Re: Written Comments Opposing SP-26-00010, Brown Road Estates II

Parcels 953834 & 428333 • 100 & 300 Anderville Lane, Ellensburg, WA
Applicant: Brown Road Estates, LLC
Zoning: Agriculture-5 • Land Use: Rural Residential

BROWN ROAD SHORT PLAT NO. 3  
PART OF SECTION 4, T. 17 N., R. 18 E., W.M.  
KITTITAS COUNTY, WASHINGTON

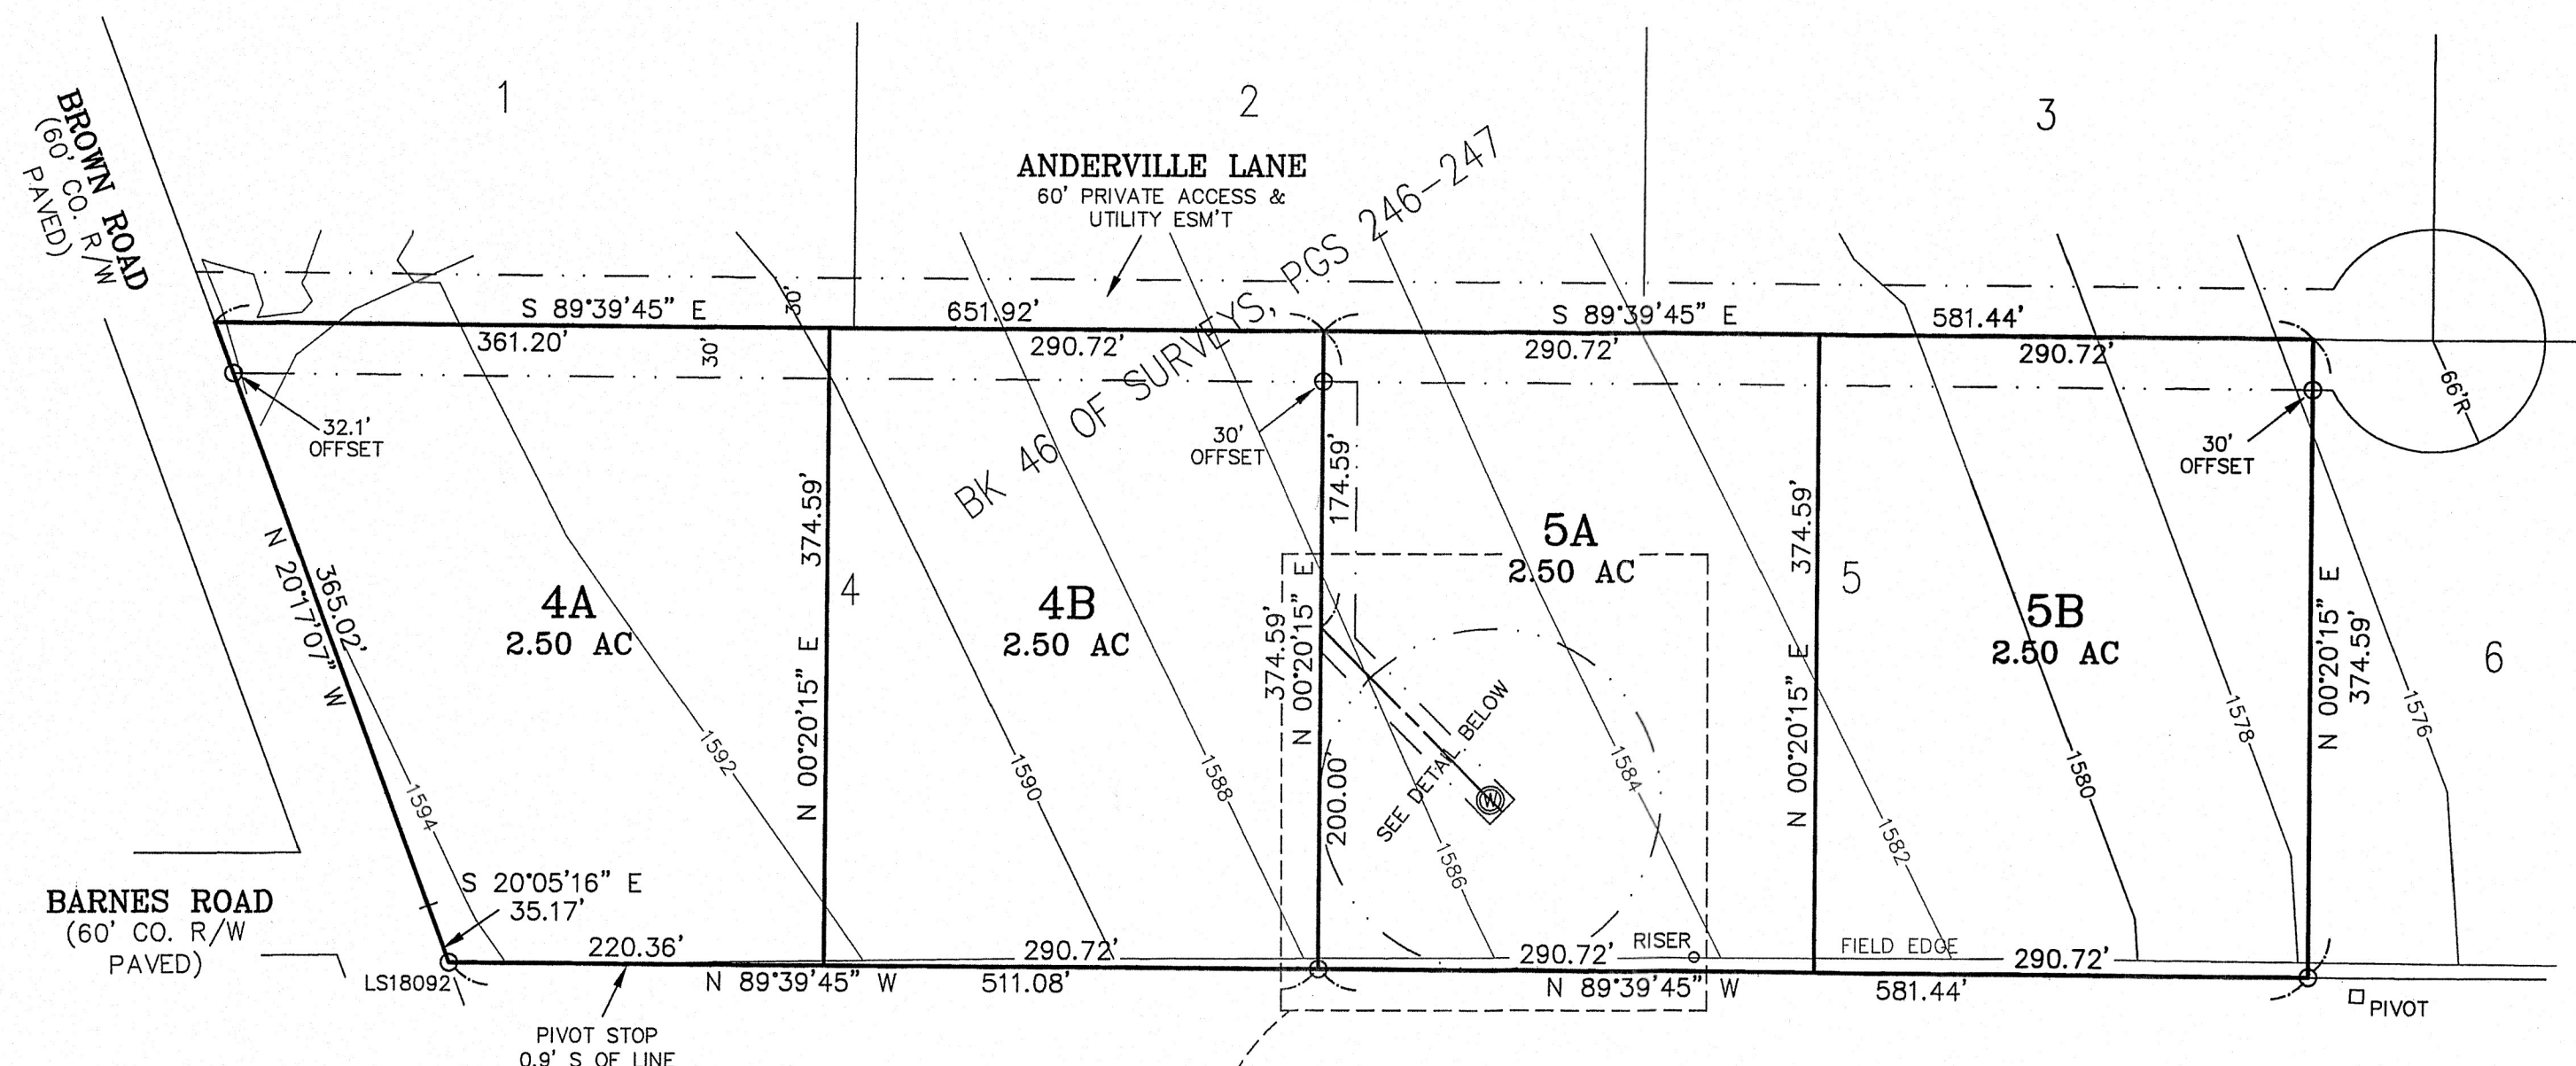
The applicant proposes four 2.5-acre lots on land zoned Agriculture-5 and states that TDR Density Credits in the form of TDR Certificates will be used “to meet the requirements of the density being requested to comply with zoning regulations.” That use of TDR is inconsistent with Washington State TDR policy, the Growth Management Act, and Kittitas County Code.

The Agriculture-5 zone requires a five-acre minimum lot size. A short plat outside an urban growth area may create no more than four lots under KCC 16.08.186 and Chapter 16.32, but each lot must still meet the underlying zone. TDR credits are not a variance from minimum lot size and are not a rezone.

The only small-lot exception in KCC 16.12.040 is a single one-to-three-acre lot around an existing residence, subject to a covenant precluding further division while the land remains designated for agricultural use. That exception does not authorize four 2.5-acre lots across two parcels.

WAC 365-196-815 requires development regulations that prevent conversion of designated agricultural land and identifies TDR as a tool to send rights from agricultural land to urban receiving areas. Four 2.5-acre residential lots on AG-5 land is conversion. It increases rural residential density, wells, on-site sewage systems, driveway cuts, and demand for rural services—the scattered rural development costs the County's TDR program was adopted to reduce.

SP-26-00010 Brown Road Estates II Zoning

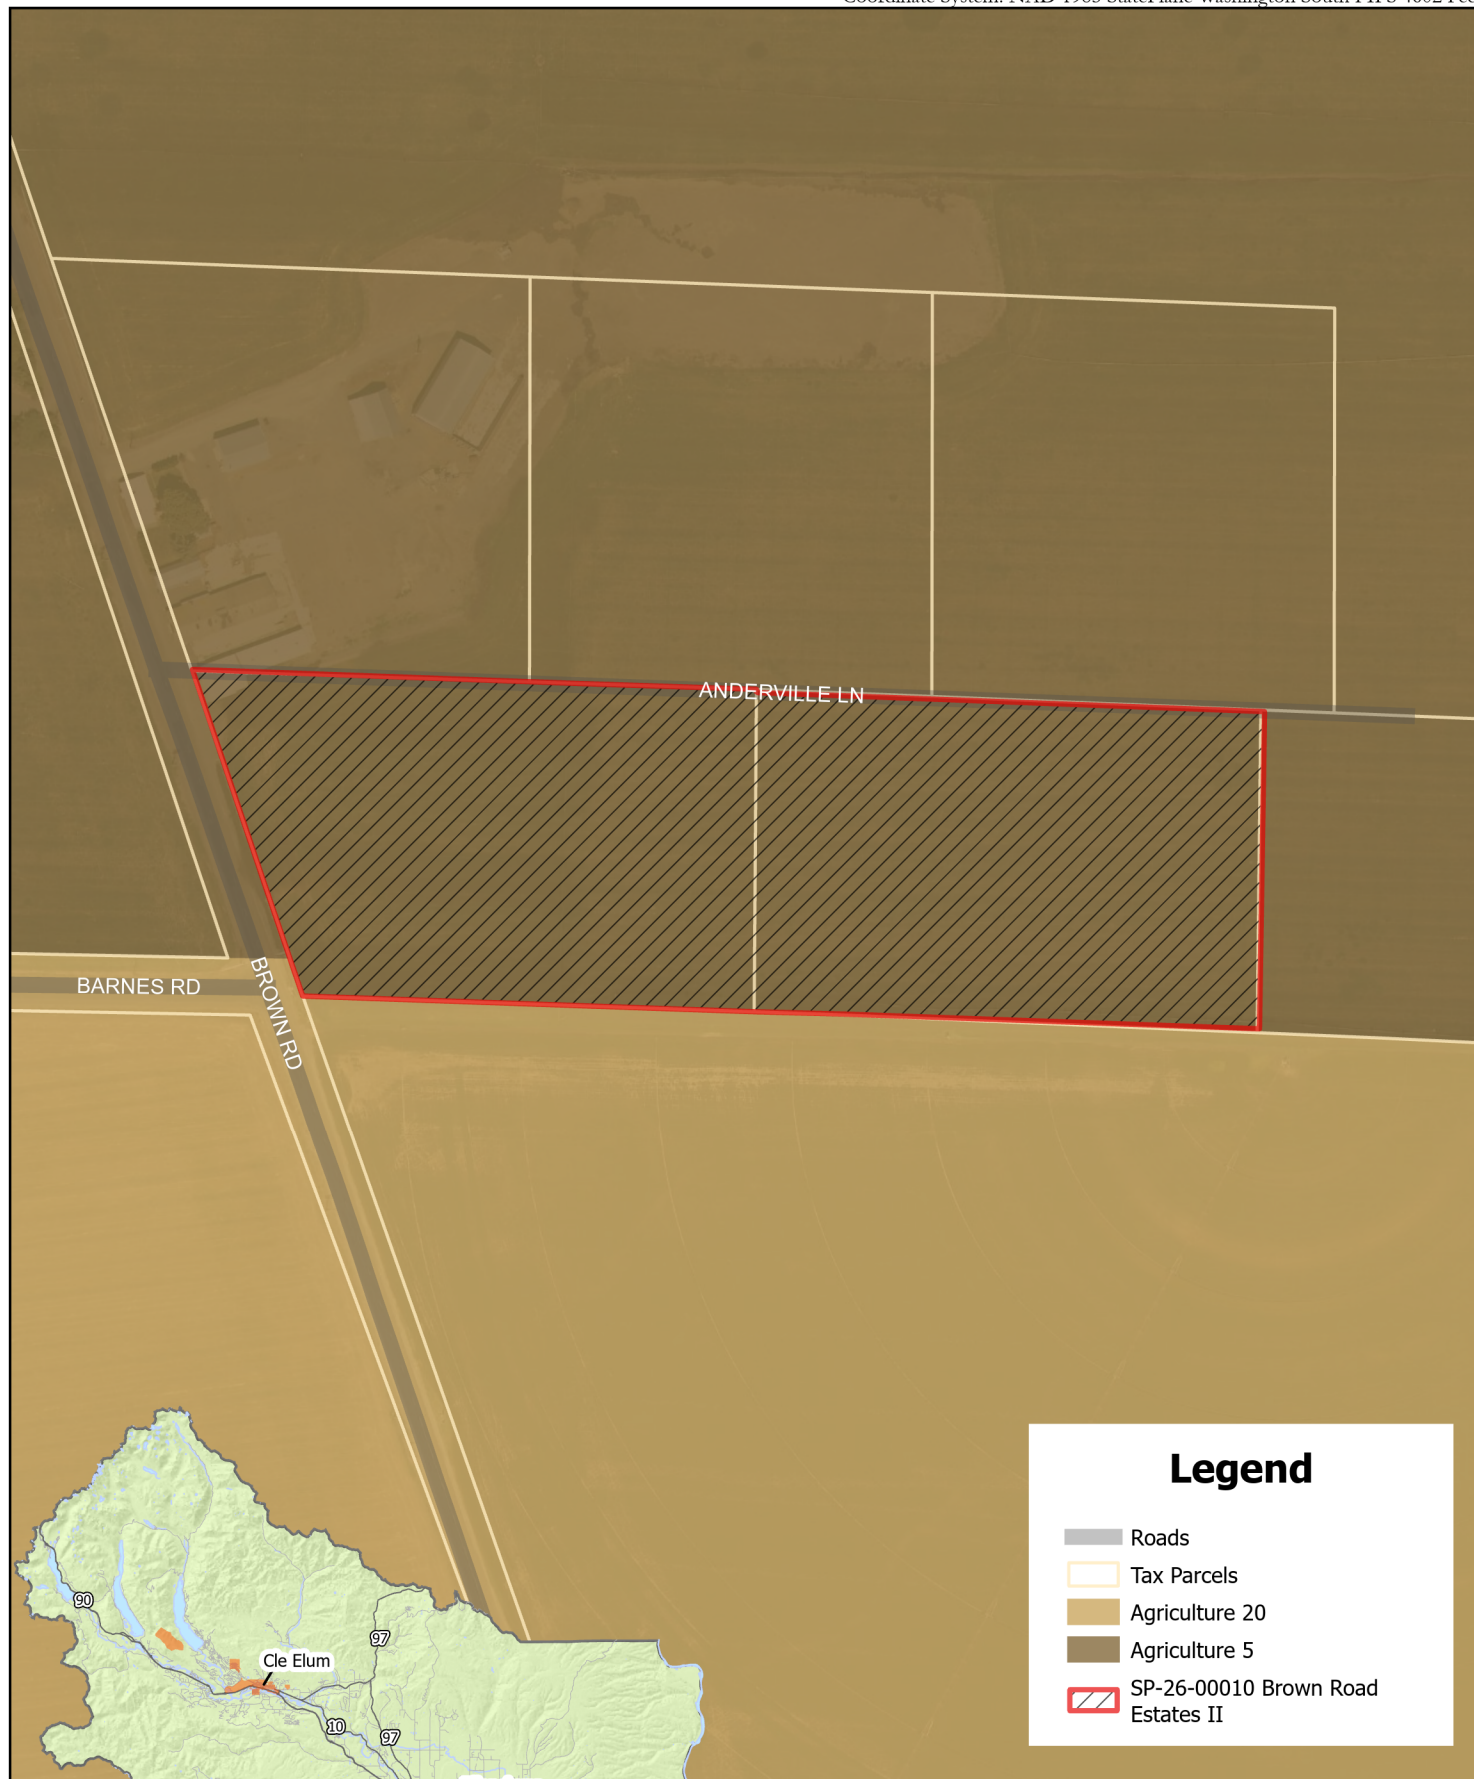
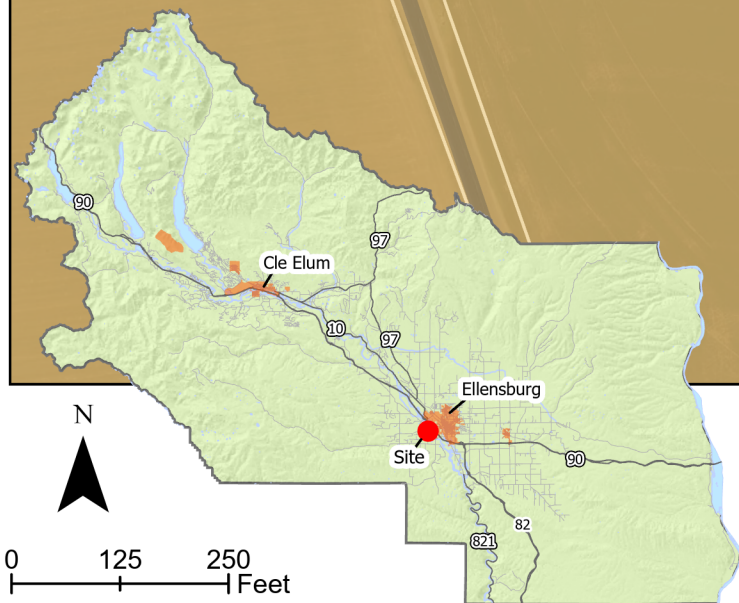
KCC Chapter 17.13 has the same purpose: permanently conserve rural farm and forest land by extinguishing development rights on designated sending sites and redeeming density credits on eligible receiving sites. Agriculture-5 land is a sending-site zone under KCC 17.13. Using TDR certificates to increase density on AG-5 land reverses the program. If the credits originated in an urban growth area, the transfer is even more contrary to GMA Goals 1, 2, and 8 in RCW 36.70A.020 (urban growth, reduction of sprawl, and conservation of natural resource industries).
